**SPORT
ENGLAND**

23 May 2011

**App Ref: WA/37/11/
Site: Land adjacent to Walberton Village Hall The street Walberton
BN18 0PQ
Proposal: Single storey pre-school. Resubmission following WA/12/11.**

Project Walberton Pre-School
Walberton
Drawing Block Plan

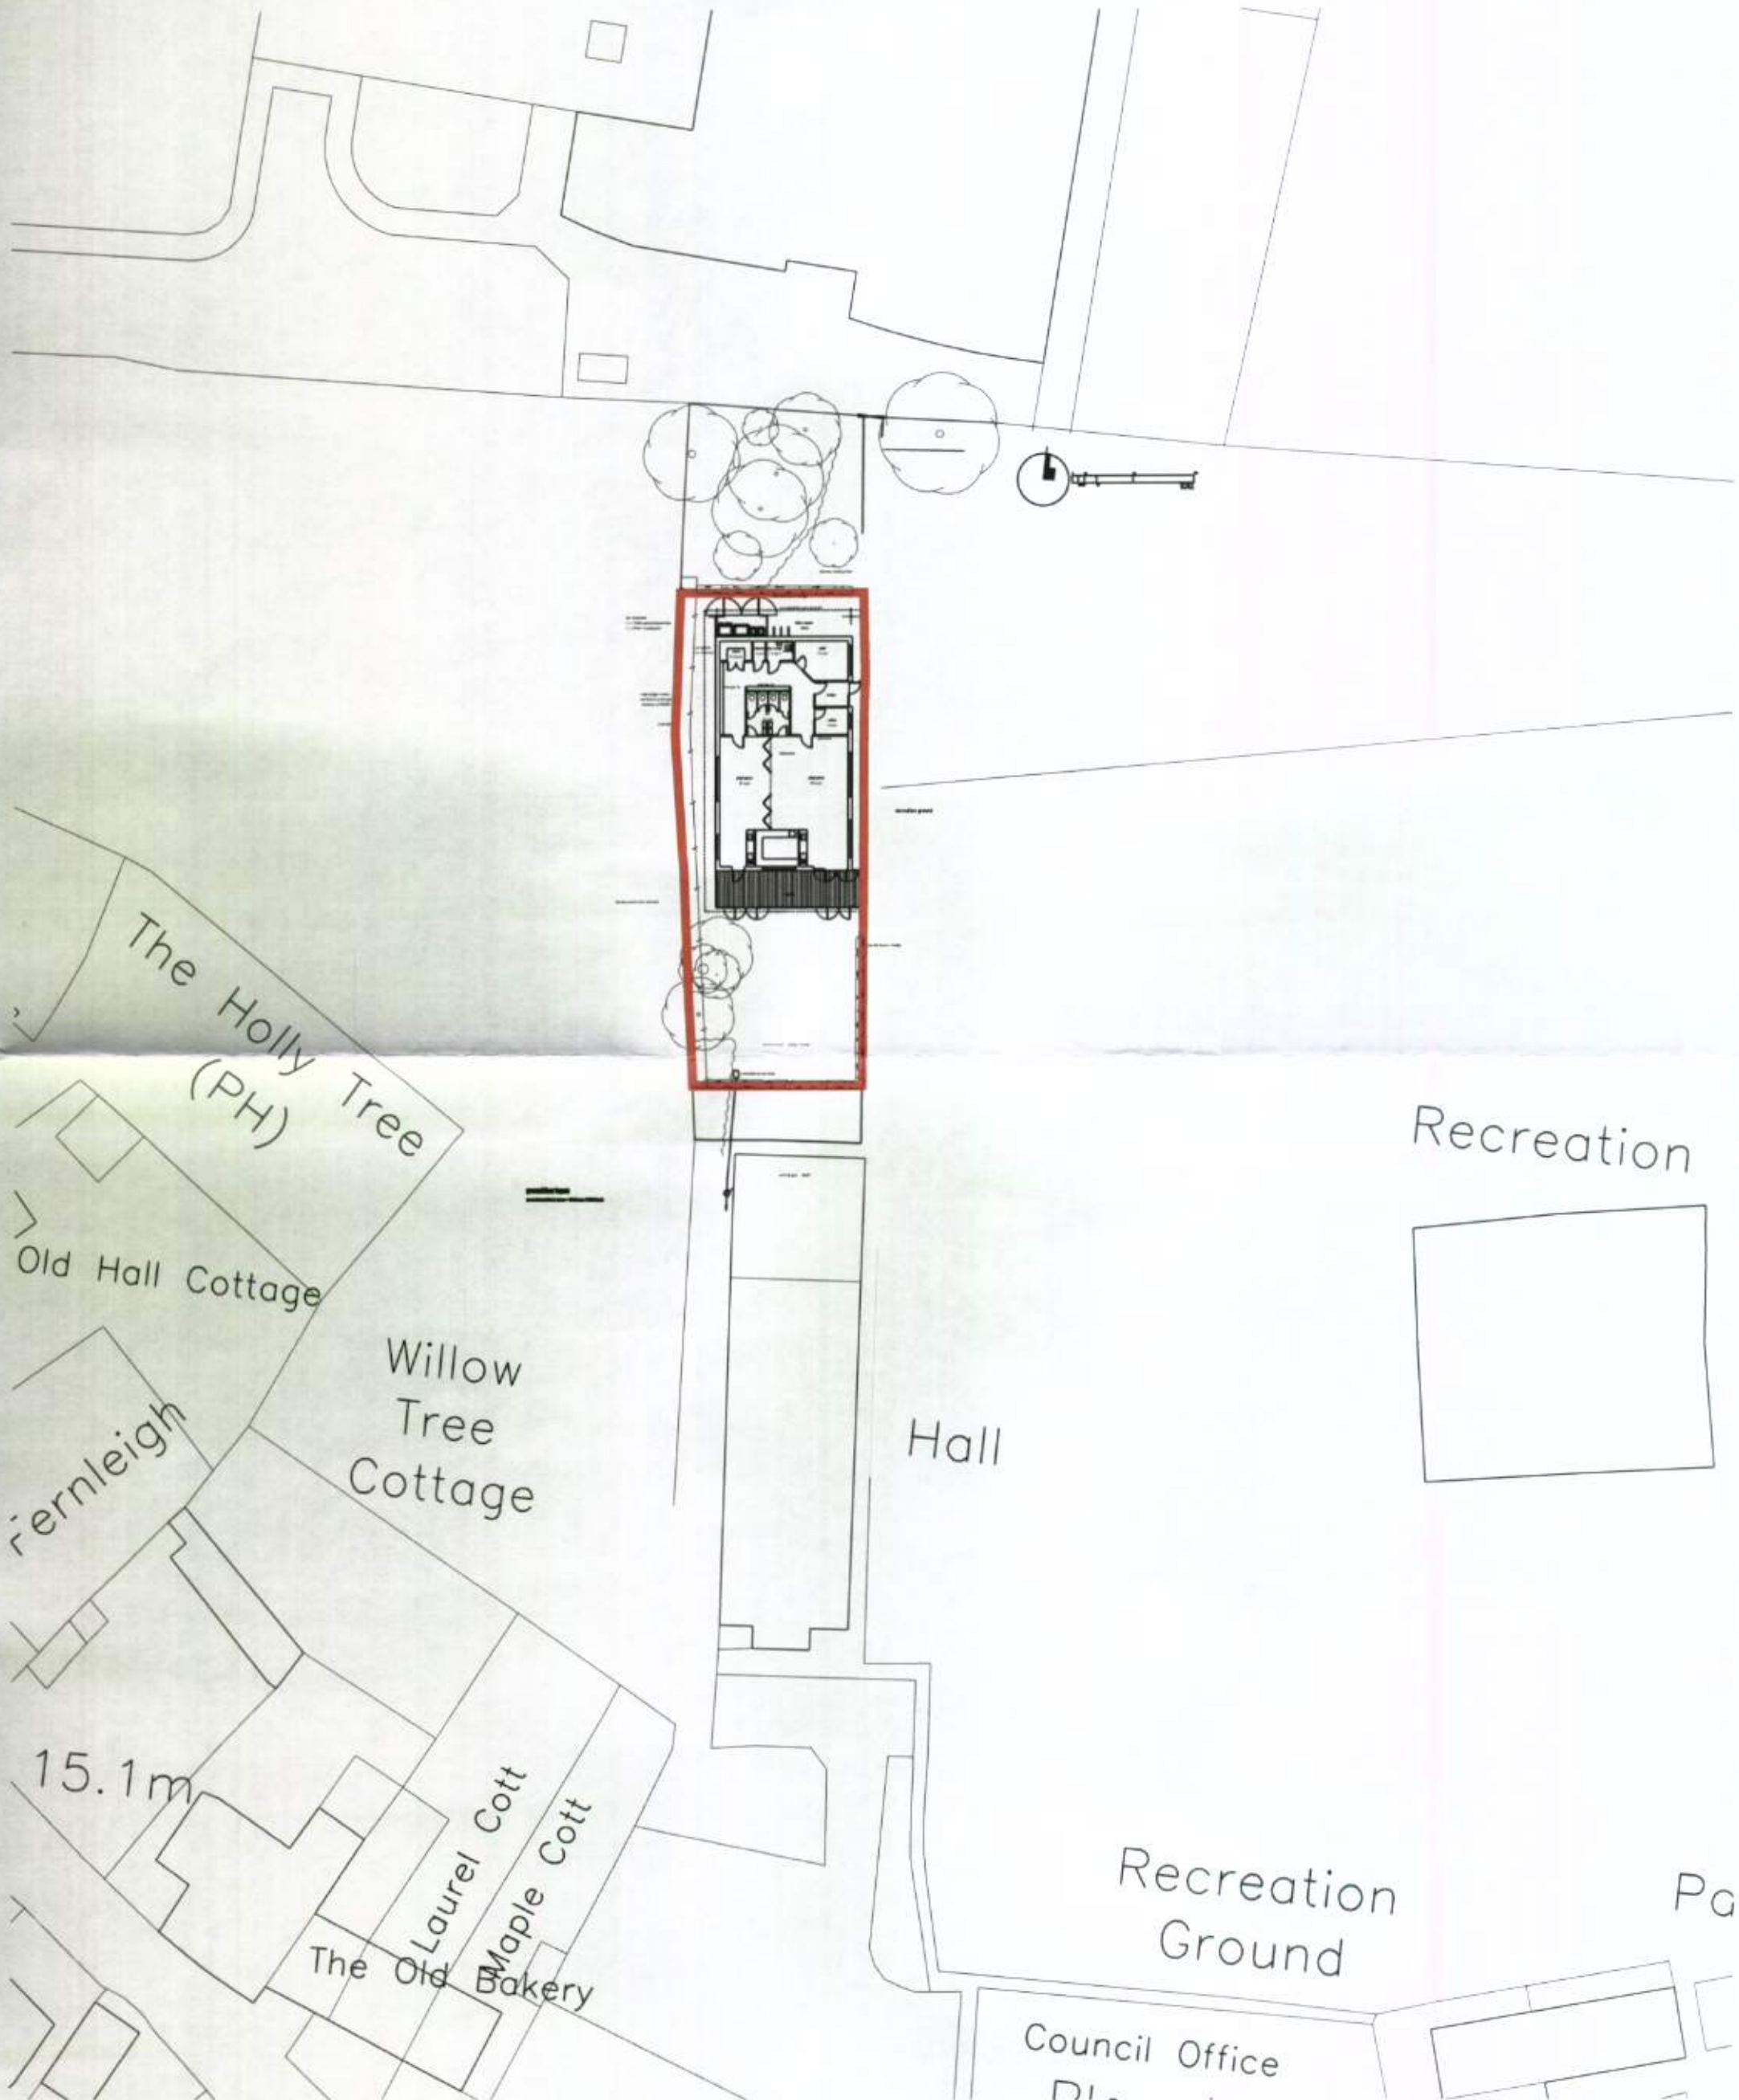
That said, the application does result in the loss of a built sports facility, namely a tennis court. It is Sport England's policy to prevent the loss of facilities which are important in terms of sports development. As such Sport England will promote policies and practices that require at least an equivalent replacement in terms of quality, quantity and accessibility if the loss of a facility is unavoidable, unless it can be proved that the facility is genuinely redundant and there is no demand for a replacement based on a thorough local assessment.

Sport England therefore seeks to understand the extent to which the existing tennis court benefits the community and thus the impact of its proposed loss. If the tennis court is to be re-provided elsewhere, then further details of this should also be provided by the applicant.
